MARINE RESTORATION & CONSTRUCTION LLC

Re: SHL23-016 SUB1 Review Letter; 9150 Fortuna Dr (Site), Mercer Island, WA 98040

We received *SHL23-016-SUB1-PLANS-013123_review.pdf* dated February 2, 2023. We have addressed the comments in the review plan set and published the responses.

We received *SHL23-016 SUB1 Review Letter.pdf* dated February 2, 2023. We have addressed the comments in the section below and have attached supporting documentation.

PROPOSED PLAN VIEW
 SCALE: 1" = 40'

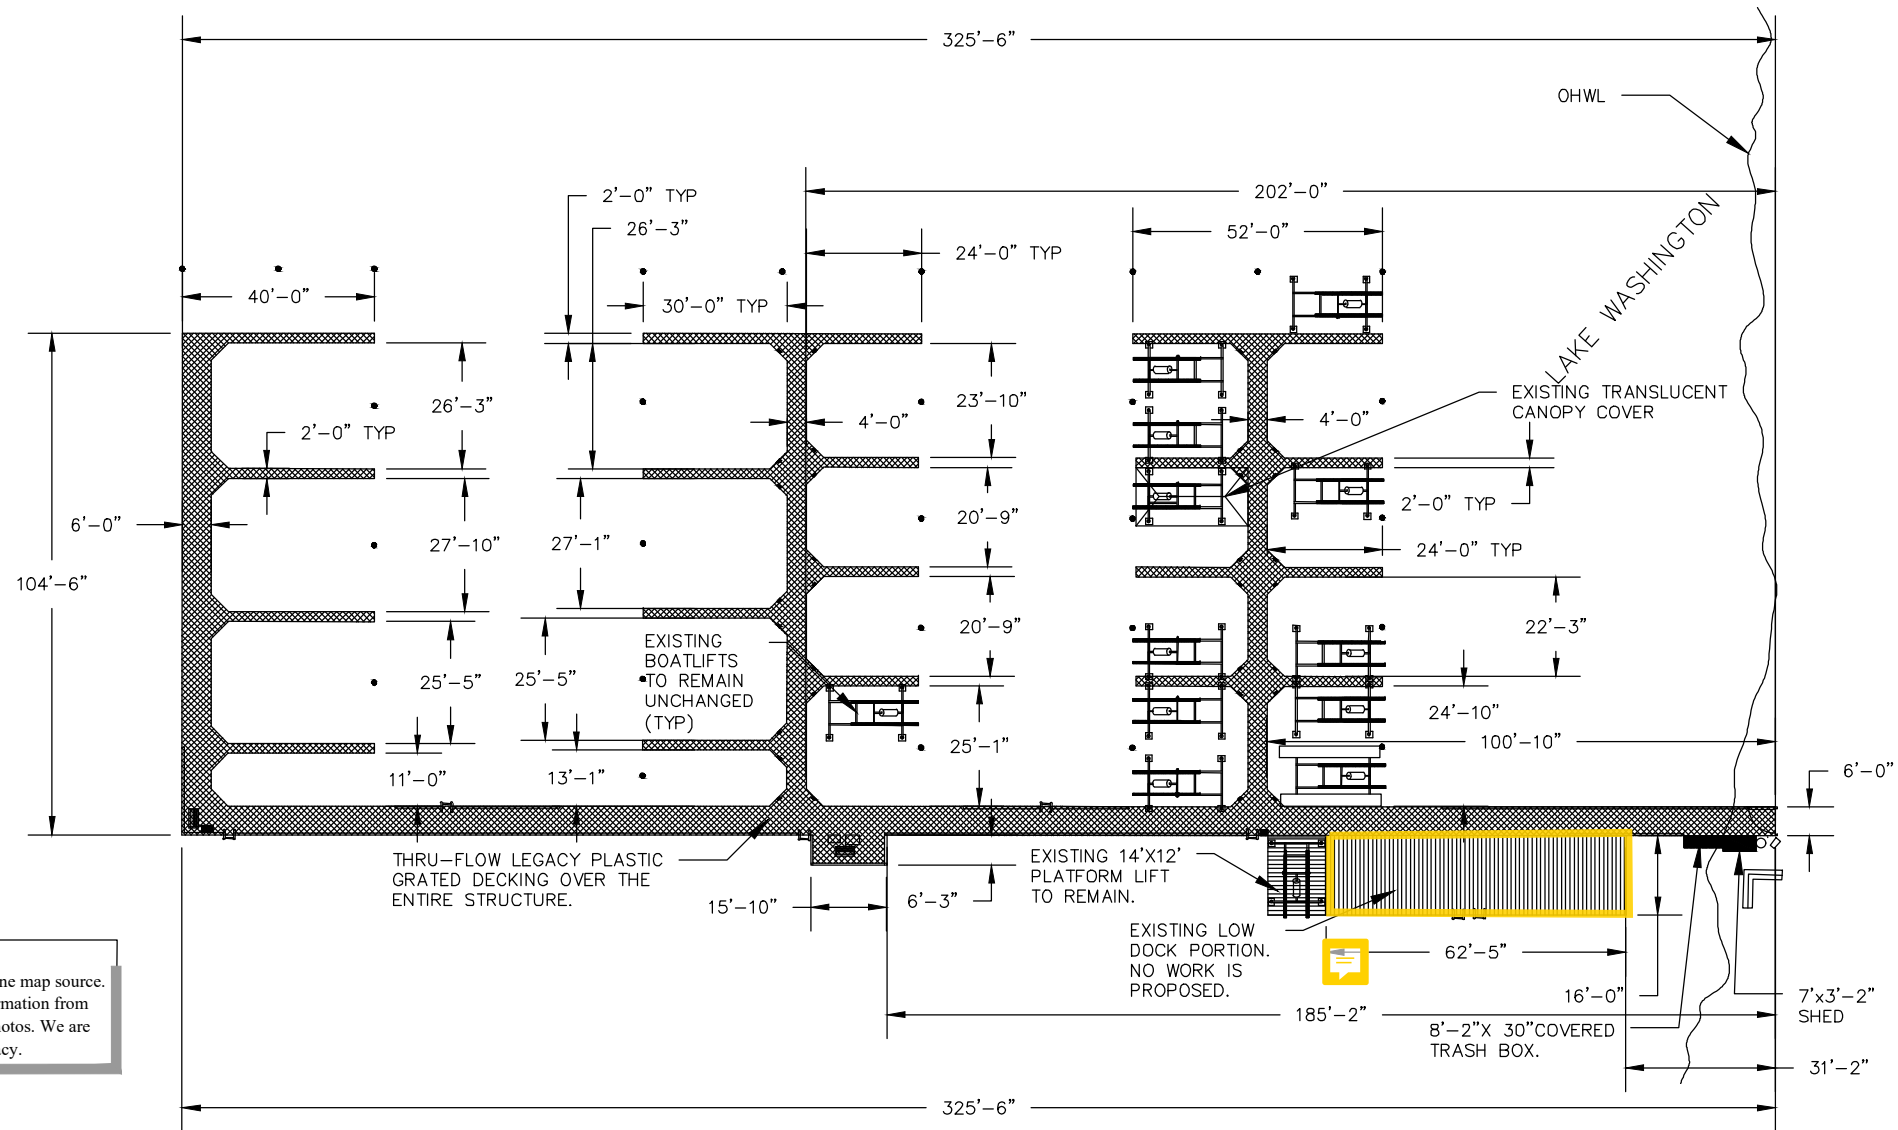
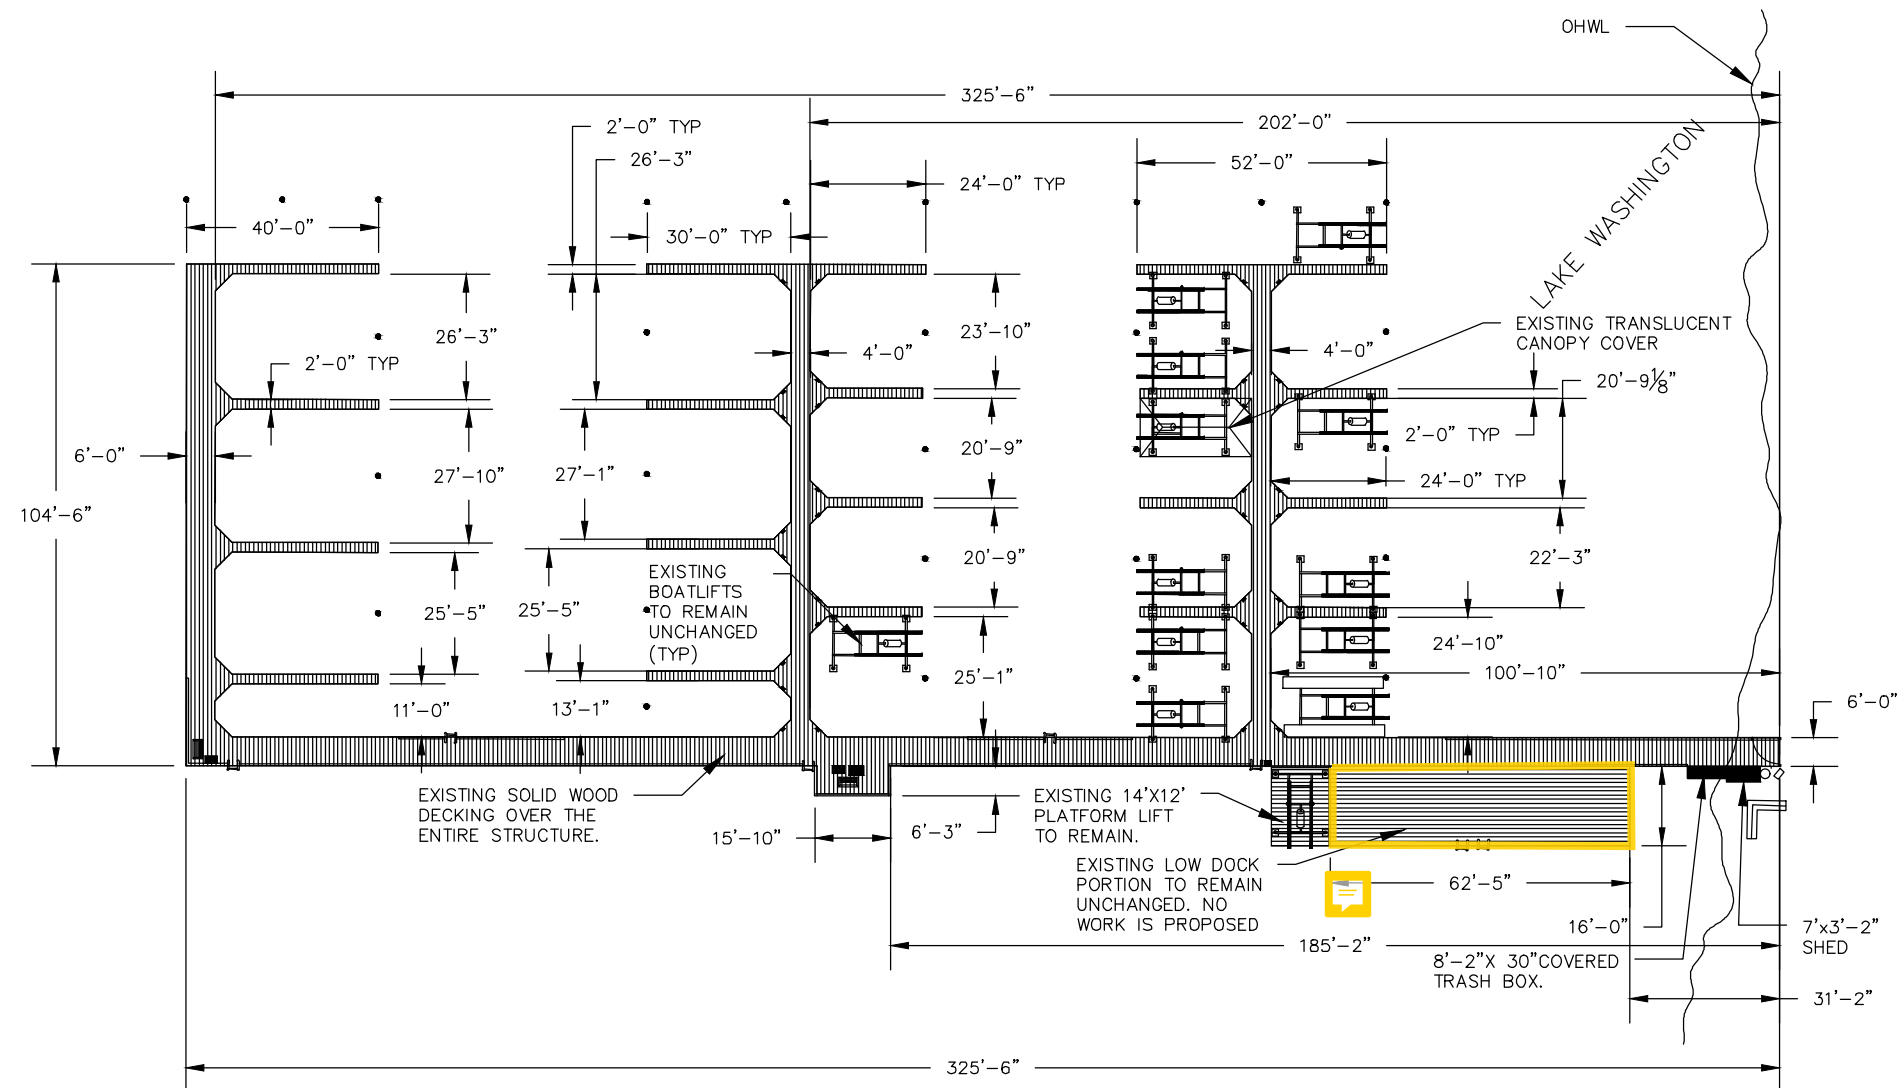
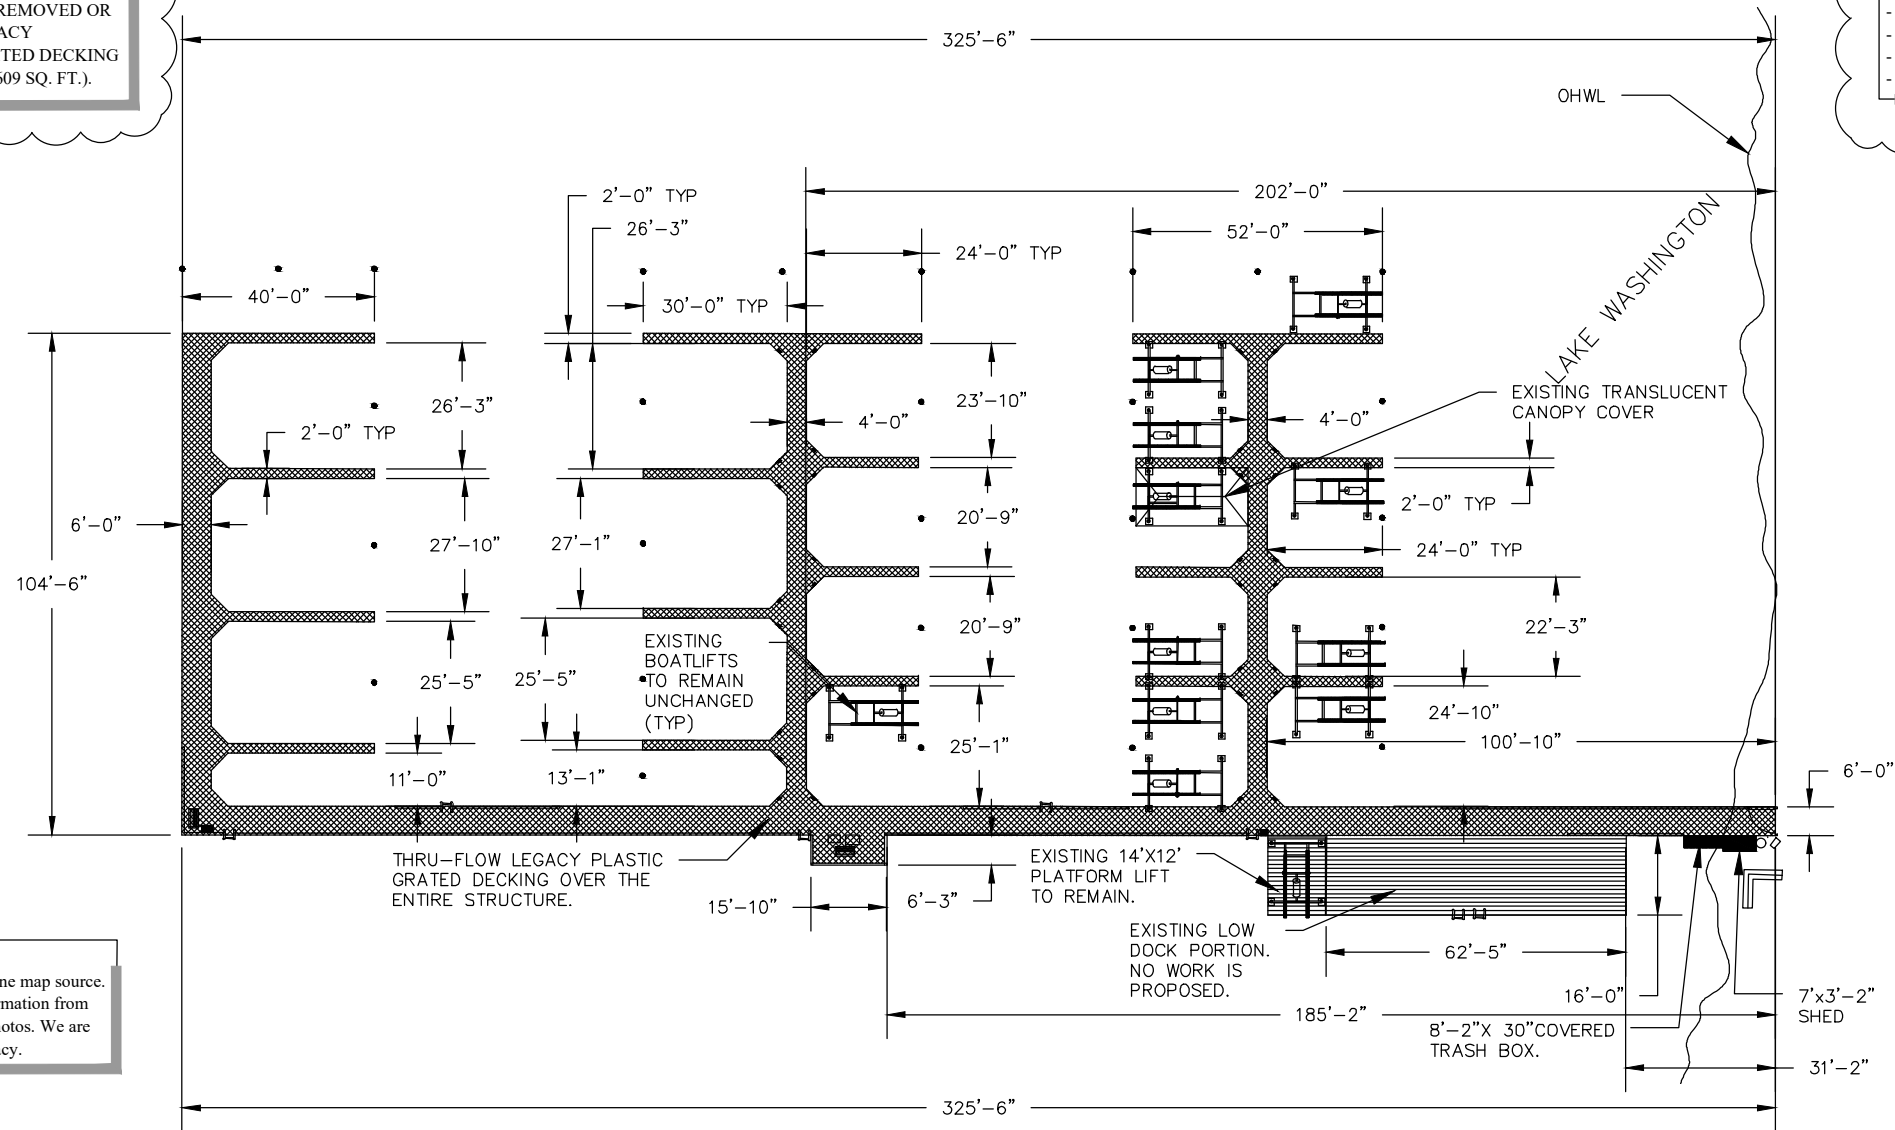
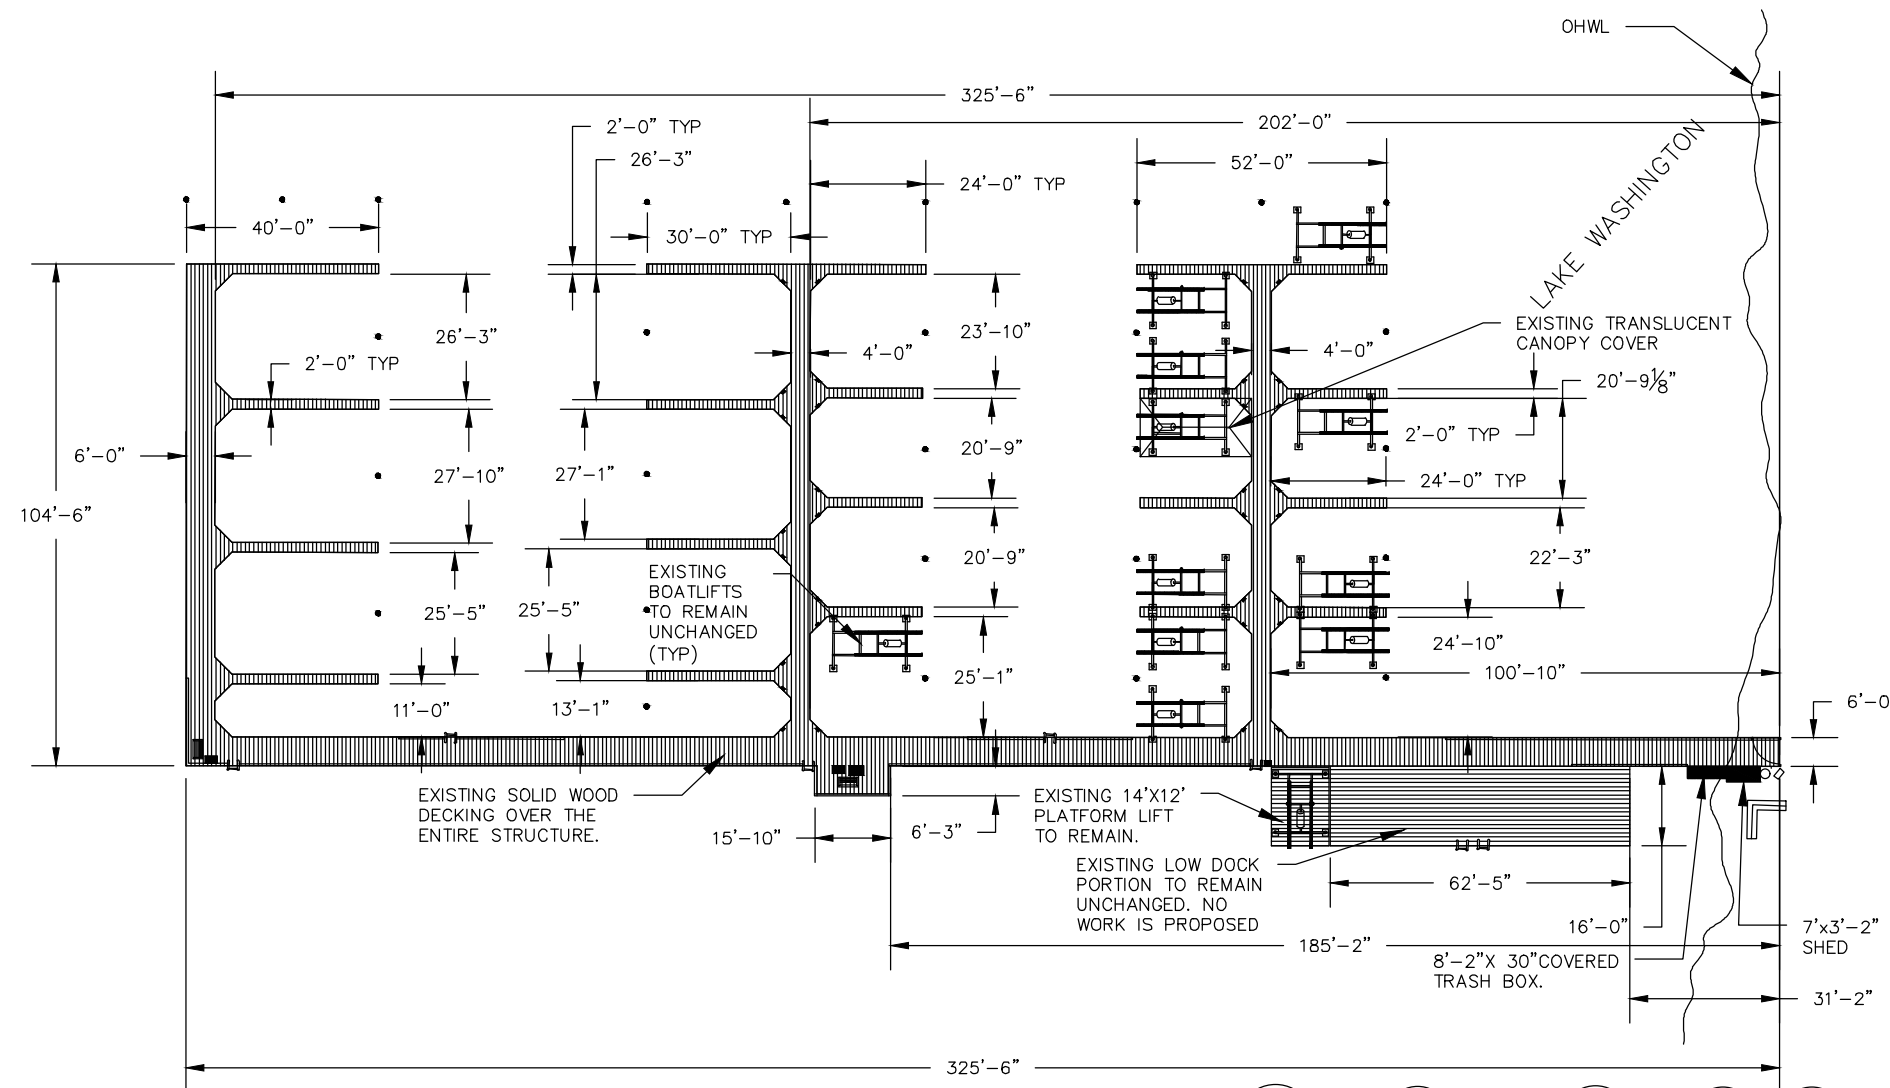
2. The existing low dock portion (highlighted on the plan set) is drawn differently on the proposed plan view than the existing plan view, which makes it appear as though work is being done on

the decking. Please make these plan views consistent to show that no work is being done on the low dock portion.

No work is proposed on the existing low dock portion. The plan view has been corrected to reflect this. Please see corrected plan set dated 2-9-23.
